DECISION DELEGATED TO DEVELOPMENT MANAGER

Application No: H19-0279-20 **Applicant:** S H & M B Properties Ltd

Proposal: Erection of 3 dwellings - approved under H19-0937-18. Amendments to fenestration and design in relation to Plot 3.

Location: Plot 3 Adj. 251 Broadgate Road Sutton St Edmund

Front Elevation
Scale: 1:100
metres

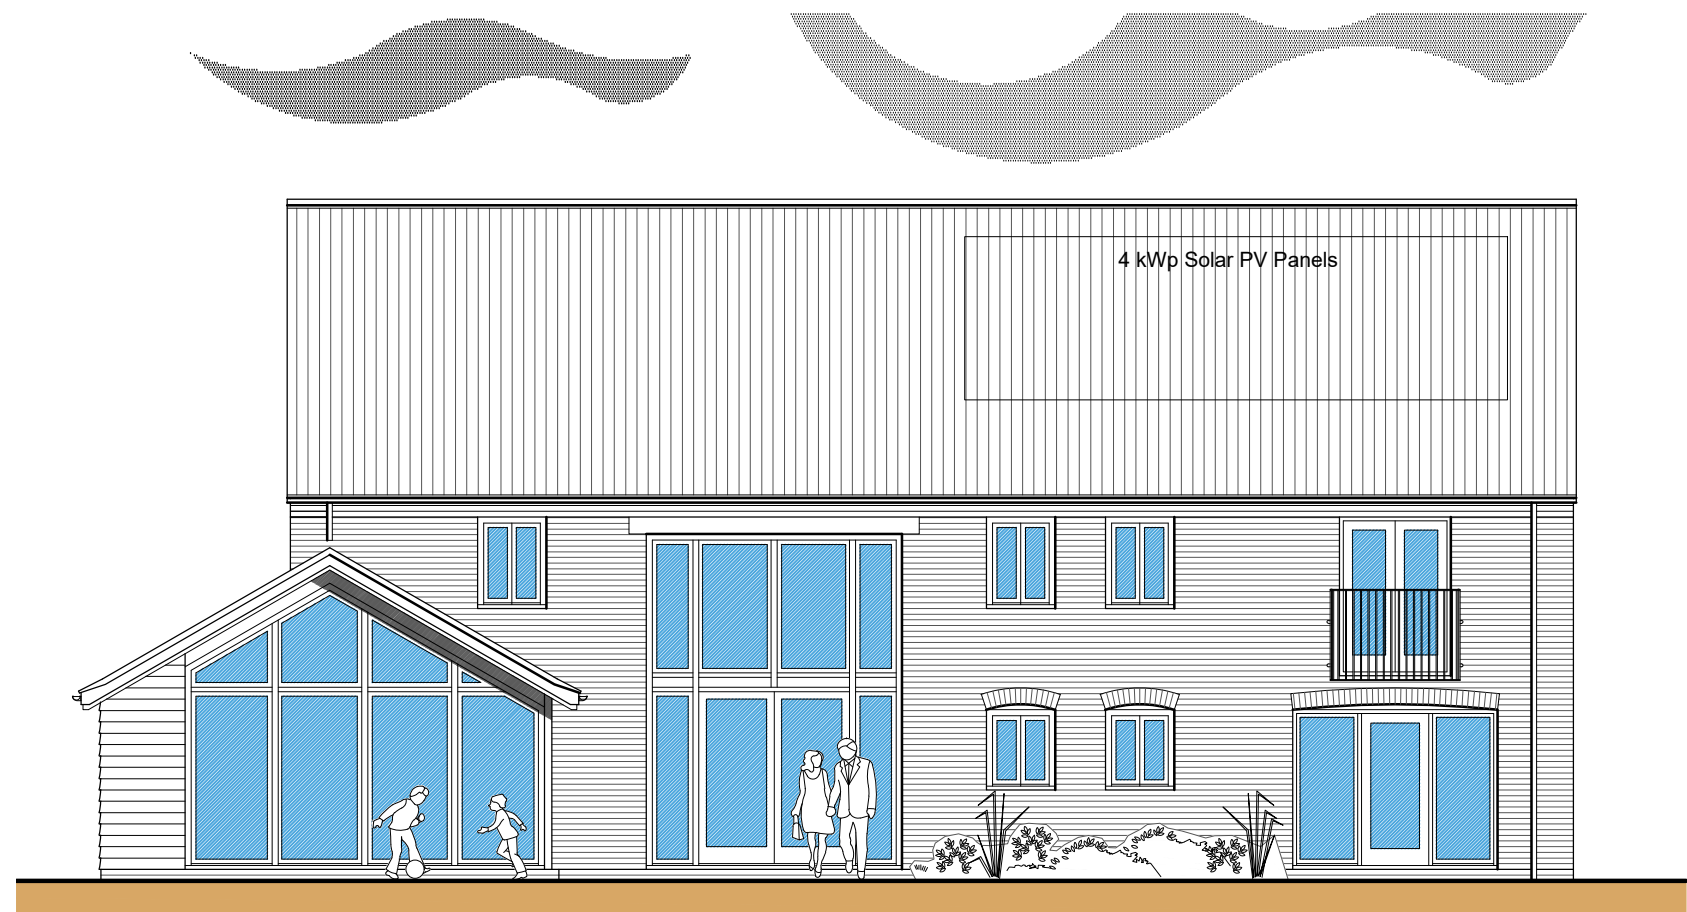
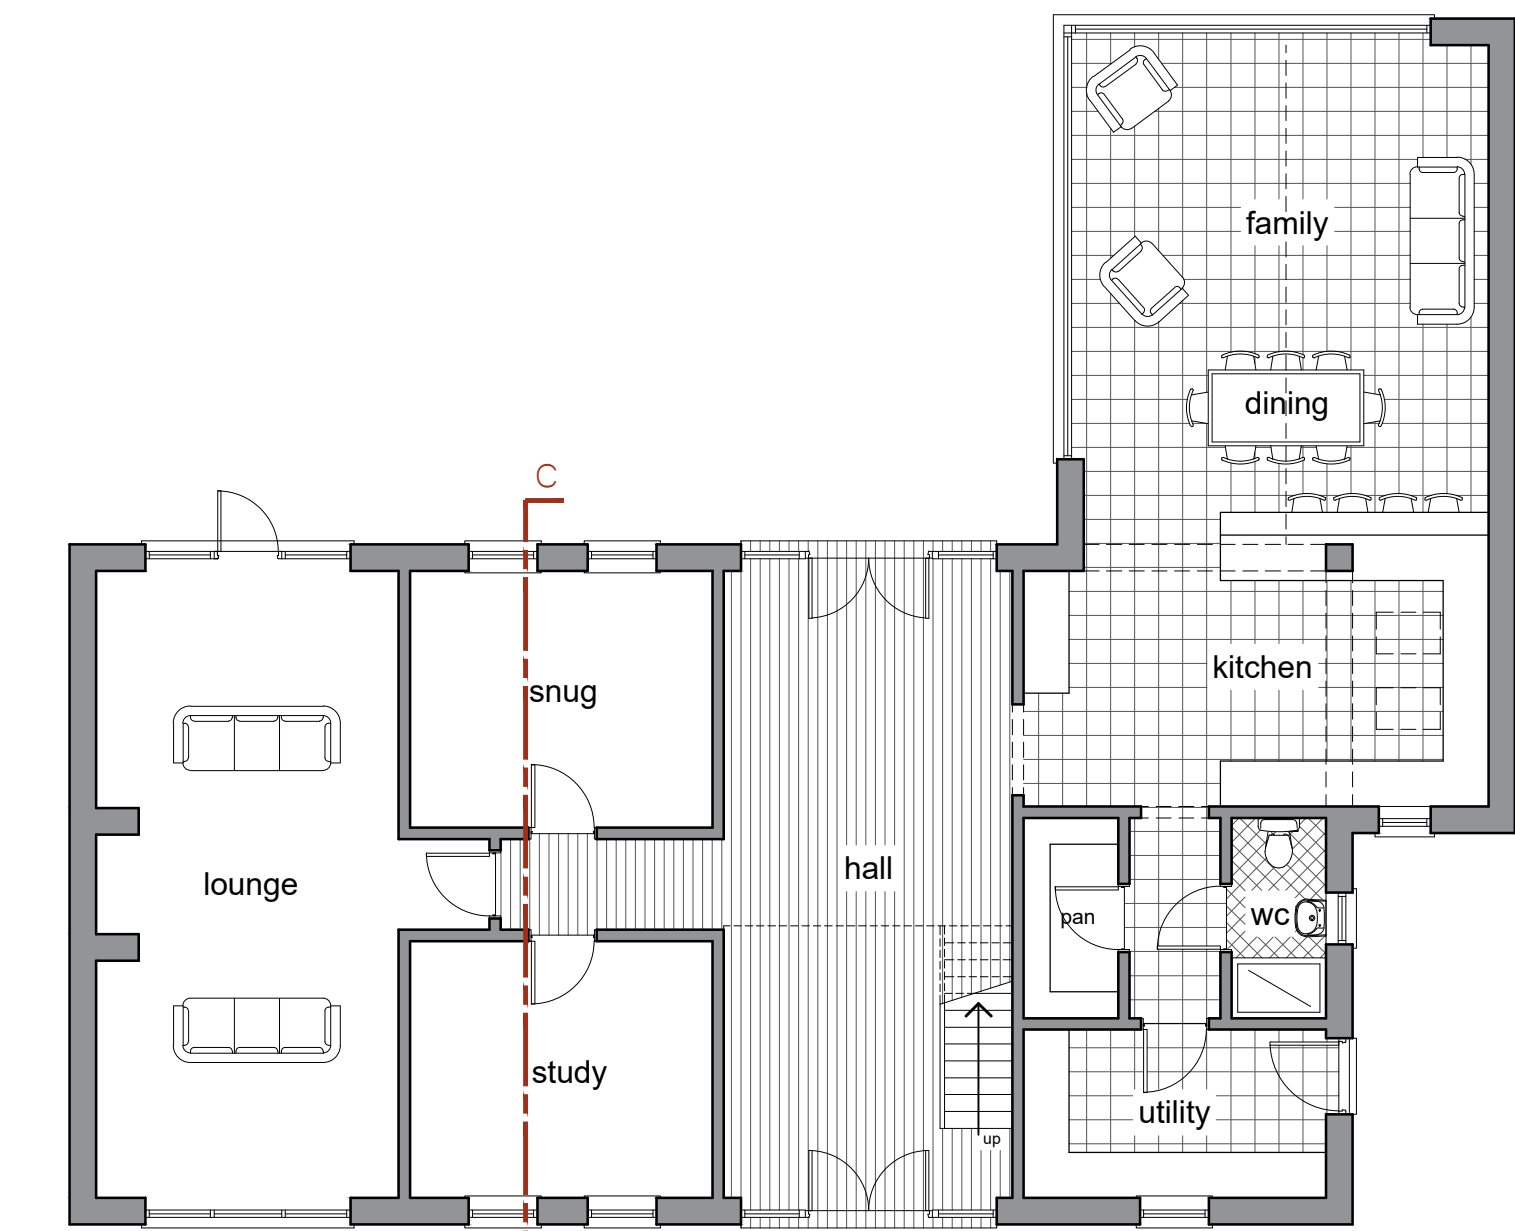
Assessing the proposal against the above, it is considered that neighbouring residents would need to be re-consulted given the proposed alterations to the front elevation. Issues have previously been raised in relation to overlooking, etc. Moreover, it is considered that some of the design alterations would erode the agricultural character of the building to some degree.
